## Jeanie Bourke - Re: Metro Lift Project- floor drains

**From:** Jeanie Bourke  
**To:** David Pinkham  
**Date:** 1/15/2013 2:15 PM  
**Subject:** Re: Metro Lift Project- floor drains

Per our telephone conversation today and the product information you have provided, the installation of the Sure Seal floor drain trap primer is approved for use in the existing floor drains at the Metro lift project on 91 St. John St.

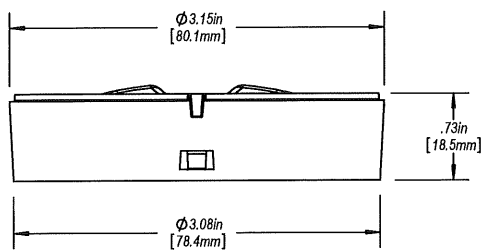
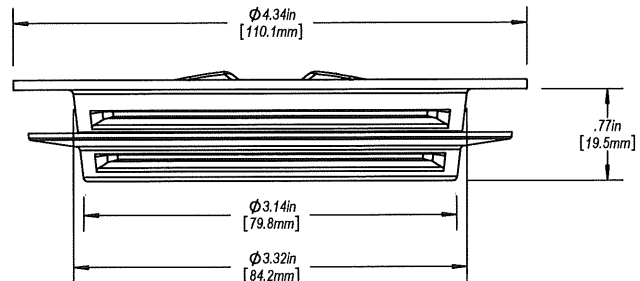
This approval is based on the 2009 UPC Sec. 301.2 Alternate Materials and Methods of Construction Equivalency & 1007.0 Trap Seal Protection. You have indicated the existing floor drains will be replaced, however the plumbing infrastructure and traps will not be substantially exposed, therefore prohibiting, within the scope of work, the installation of water lines for trap primer connection. This approval does not allow any other alternate materials or plumbing systems and requires that all new plumbing fixtures and installations comply with the requirements for new.

Please keep in mind, upon inspection of this work, assessment for code compliance is at the discretion of the city official and is binding. If the installation of water lines to existing floor drains with infrequent use, is feasible, they shall be required, any new floor drains and traps shall meet the code for new installations.
